T.J. EDENS MRICS
29 CANFORD CLOSE, ENFIELD
MIDDLESEX EN2 8QN

15 October 2014

**ERECTION OF NEW PUBLIC HOUSE AND ASSOCIATED WORKS
LAND OFF COMET WAY, HATFIELD AL10 0XY
APPLICATION REF S6/2014/1443/MA**

Drawing Title:
Landscaping and Acoustic Fence

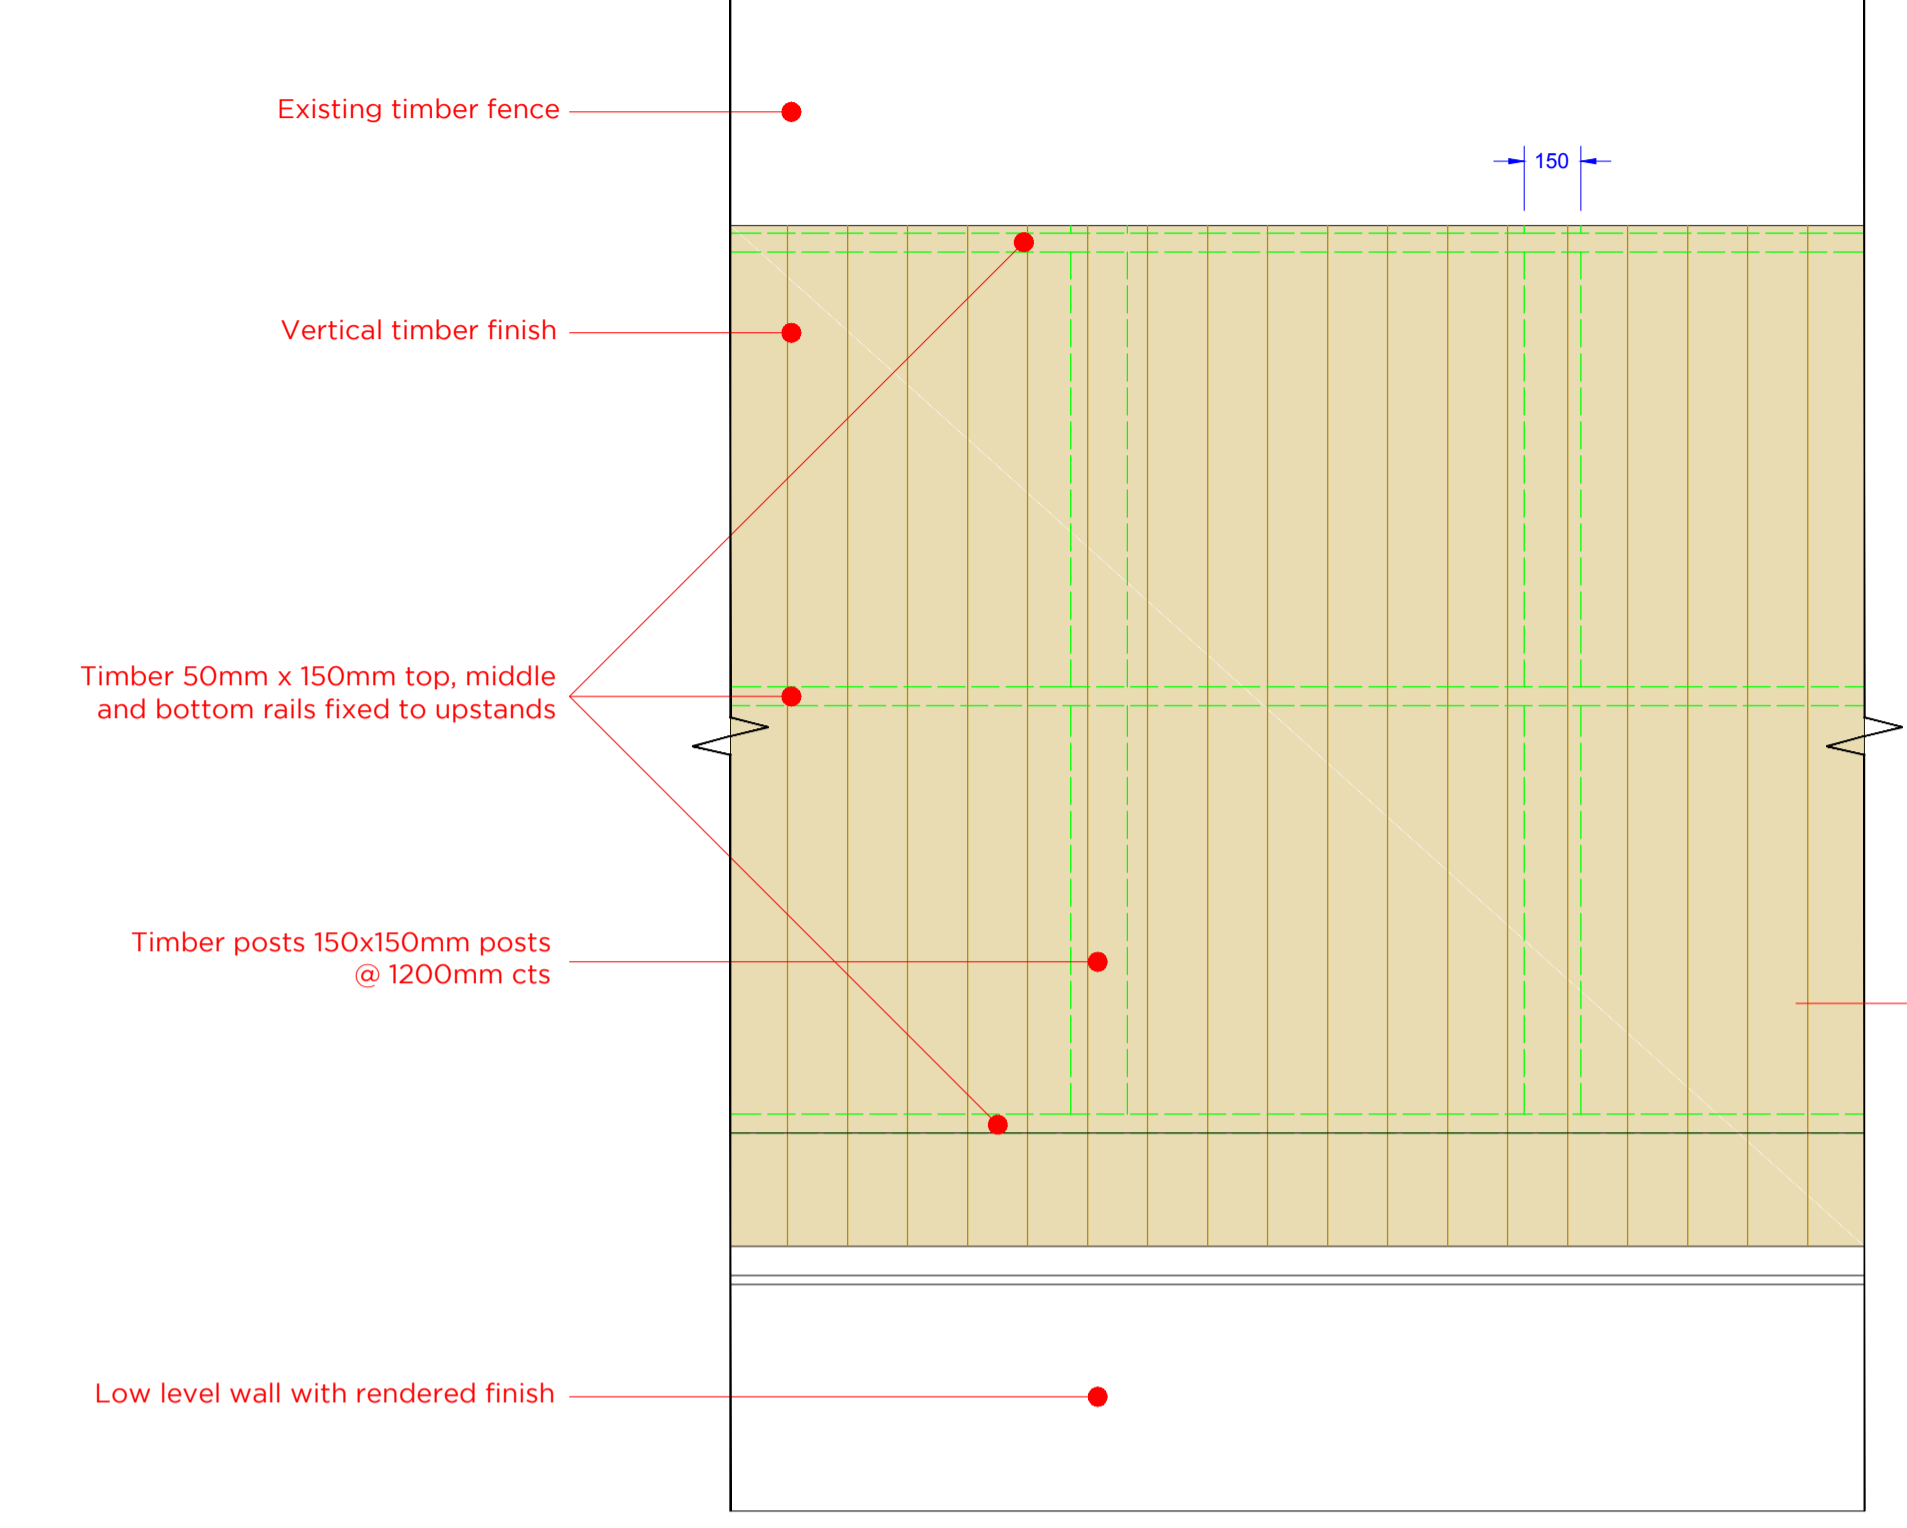
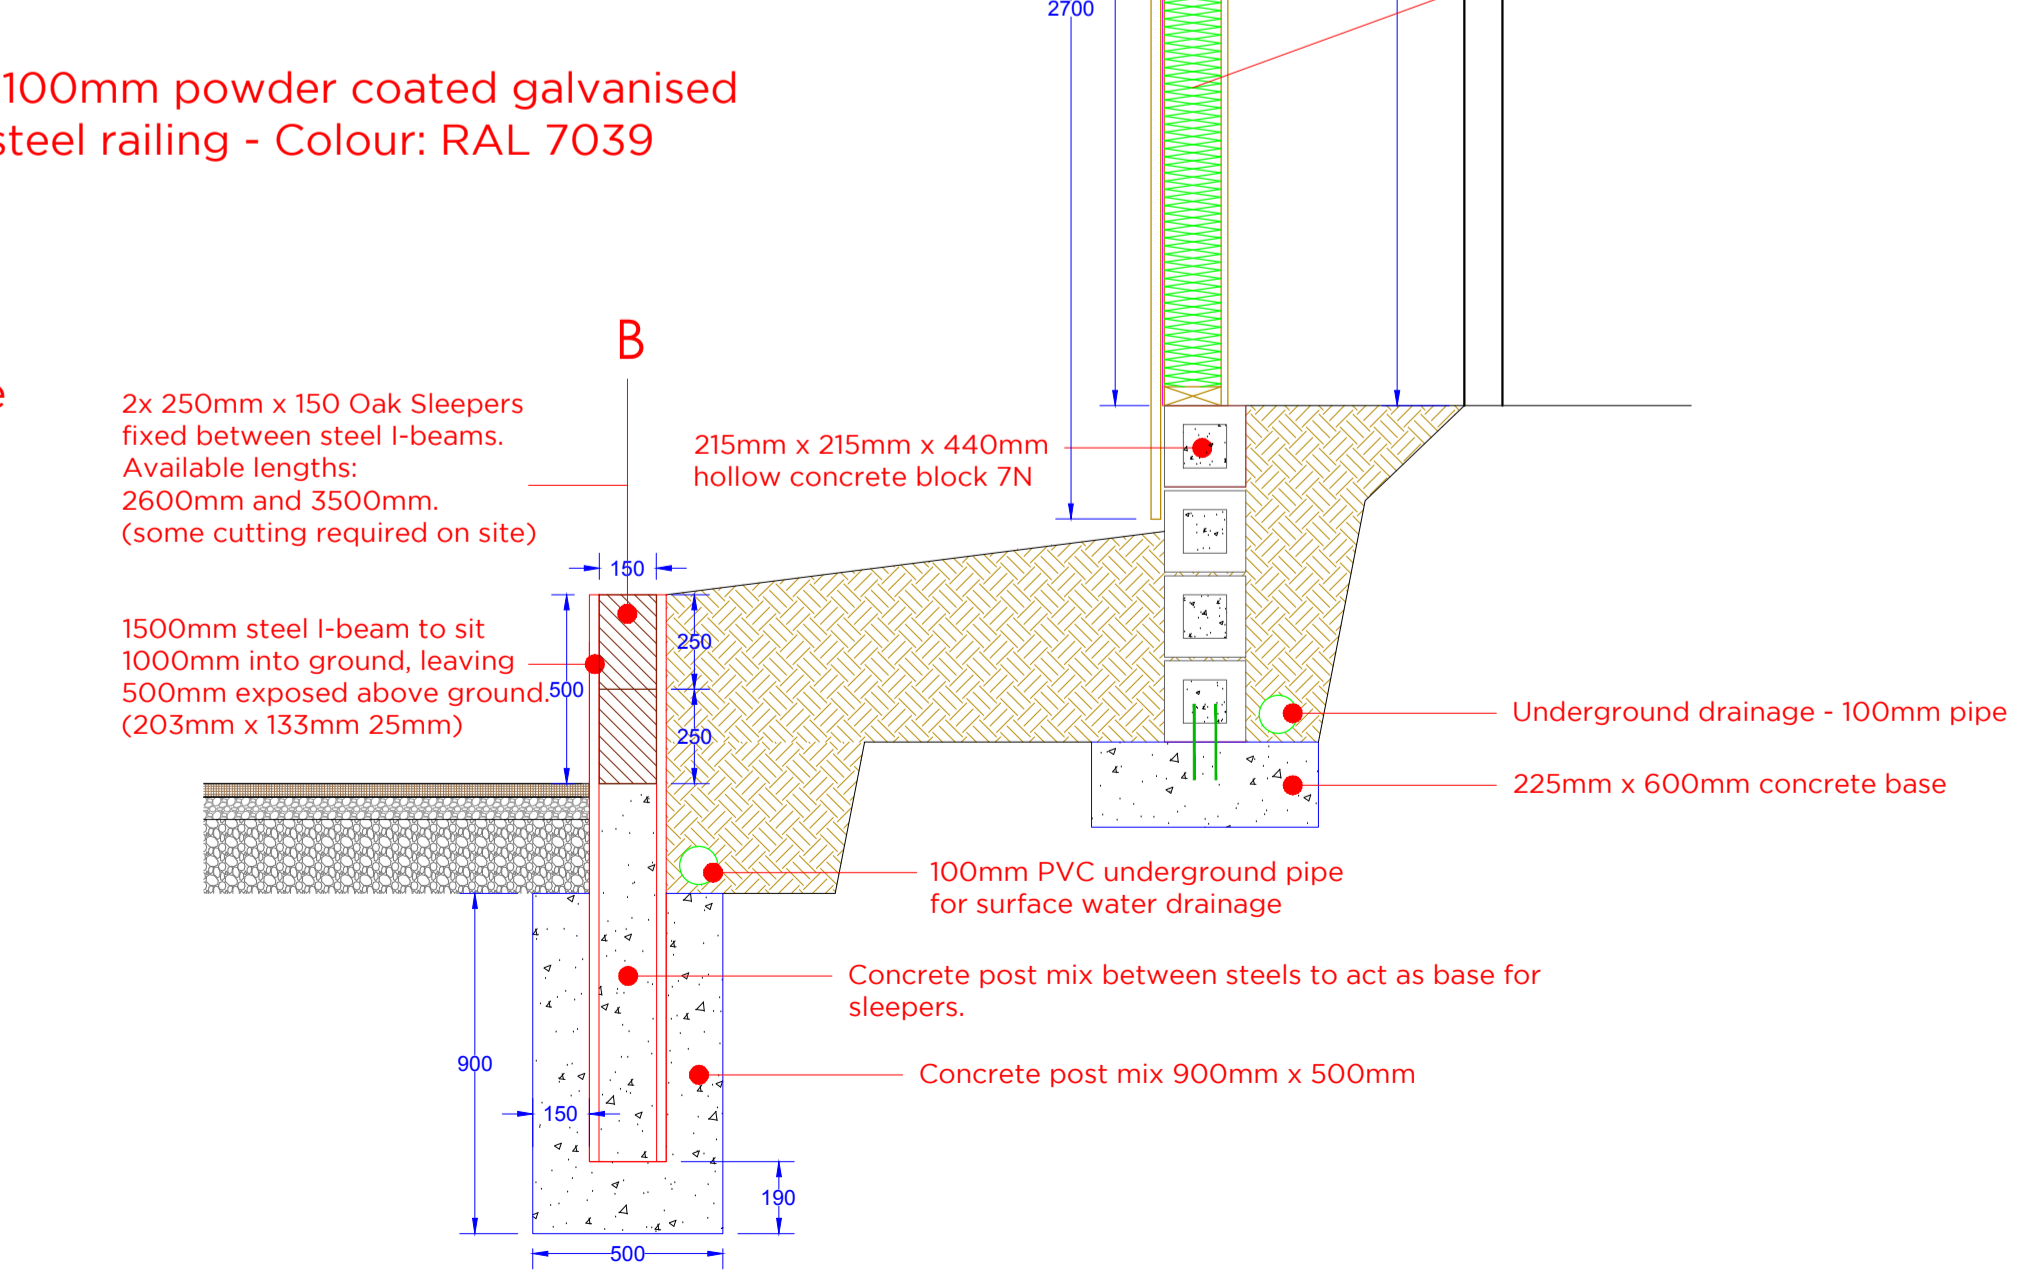
Our client's primary objective is to provide a high level of comfort to its residents and this includes sleep. With such a large area outside, our client's hotel is going to be subject to very loud noise every day of the year in summer and winter. The clientele of a typical Wetherspoons has a young demographic type such as students where excess drinking, late nights, loud traffic movements such as the revving of engines and the slamming of doors is the norm. We are aware that a premises licence application has also been submitted and this notice refers to a 1am finish on Thursday, Friday and Saturday nights. This is way too late for four star hotel residents and exacerbates the above concerns.

Further noise will be experienced by our guests due to the unloading of empty bottles into skips (whatever the restrictions say, this will happen at all times of day and night) compounded by early morning deliveries, the squealing of air brakes and rubbish trucks. Air conditioning and fridge / freezer condensers running all night will increase the ambient noise levels. Overall, all the above will have an adverse impact on comfort of our guests and will be detrimental to our business.

01 GROUND FLOOR PLAN
1:100 @A1

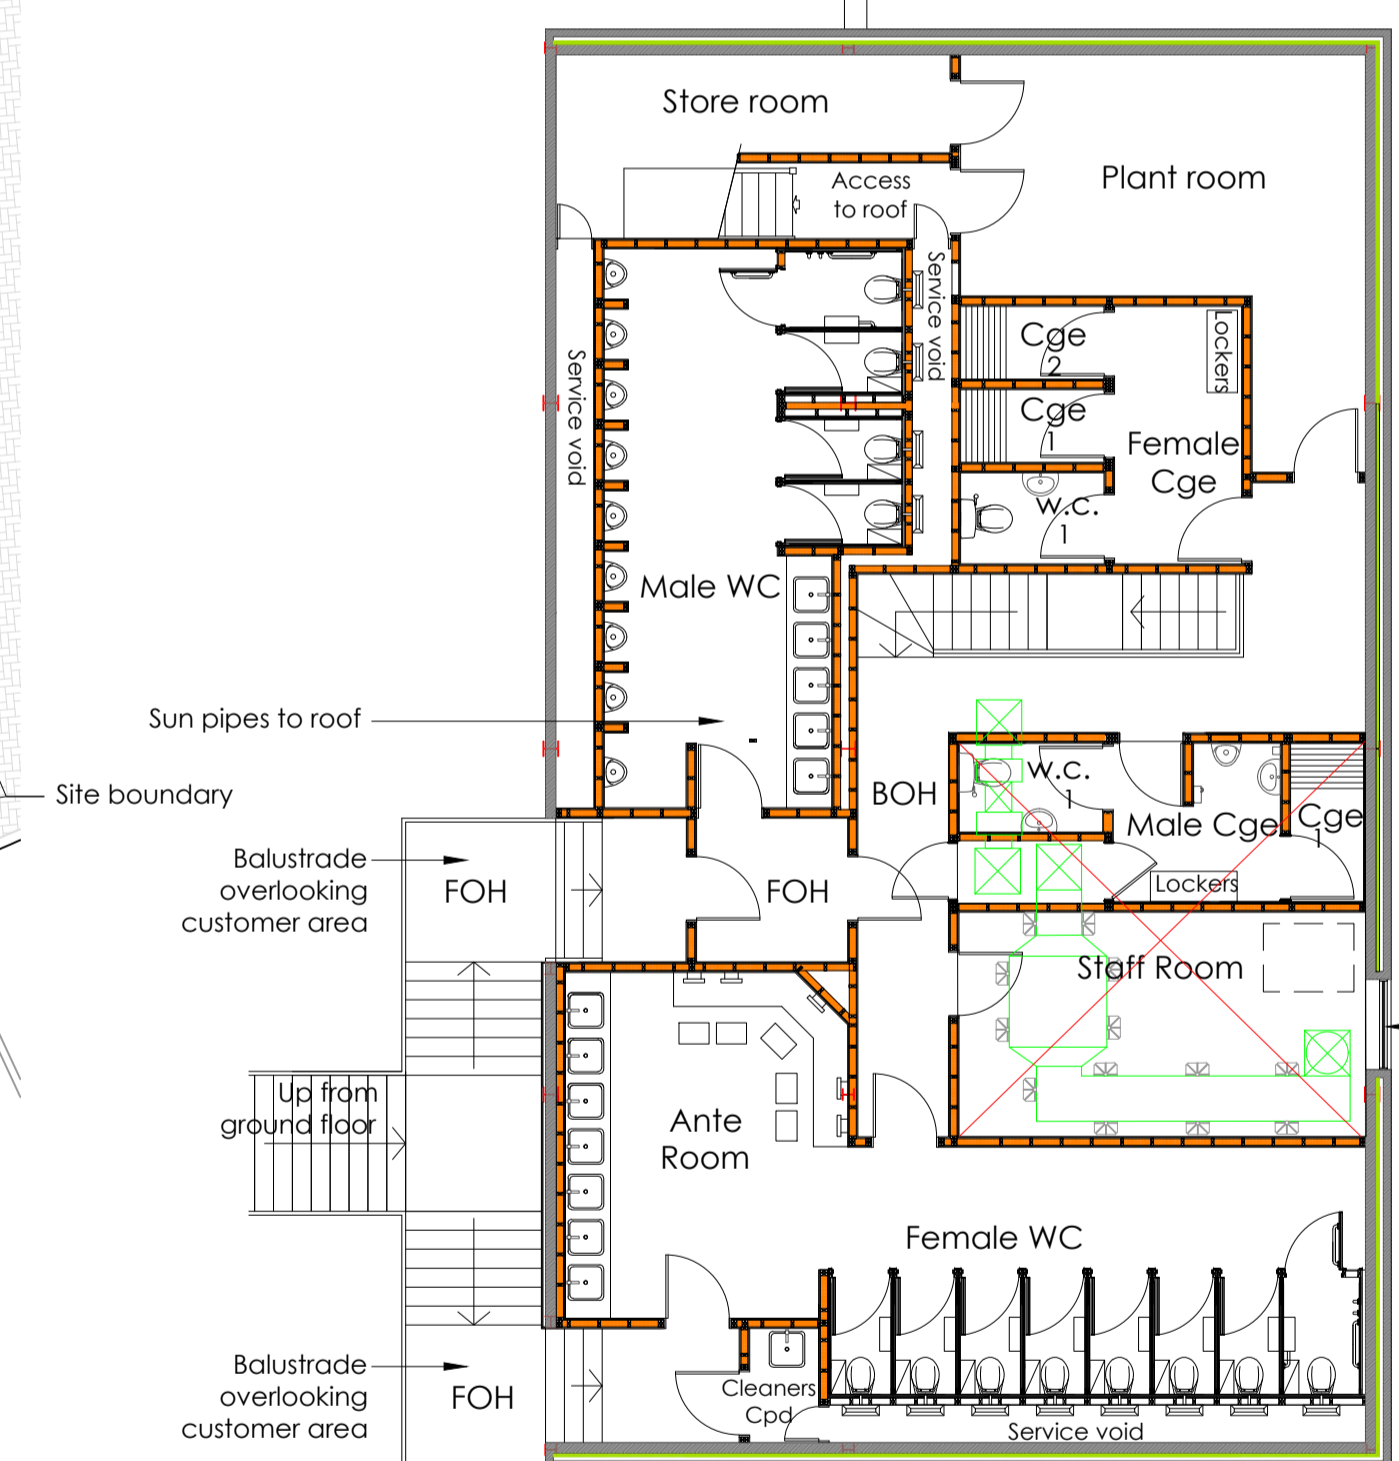
Our client's guests will be sleeping just yards away from the kitchens of this proposed Wetherspoons and it is our view that inadequate provision has been made for the dispersal of smells by way of extraction and filtration.

Our client's car park is free. There is a real danger that it will get overwhelmed with cars from Wetherspoon's guests from day one. The car park in Comet Square is free for one hour and then after that, very steep charges apply. For instance, a three hour visit to Wetherspoons for dinner will cost the customer an additional £7.50 as car park charges apply 24 hours a day. Our client is already subject to nuisance parking by students at the University and by visitors to the Galleria. Given this scenario, our client would have no other option than to erect a barrier control, at cost, which could also create traffic danger on the fast moving Comet Way
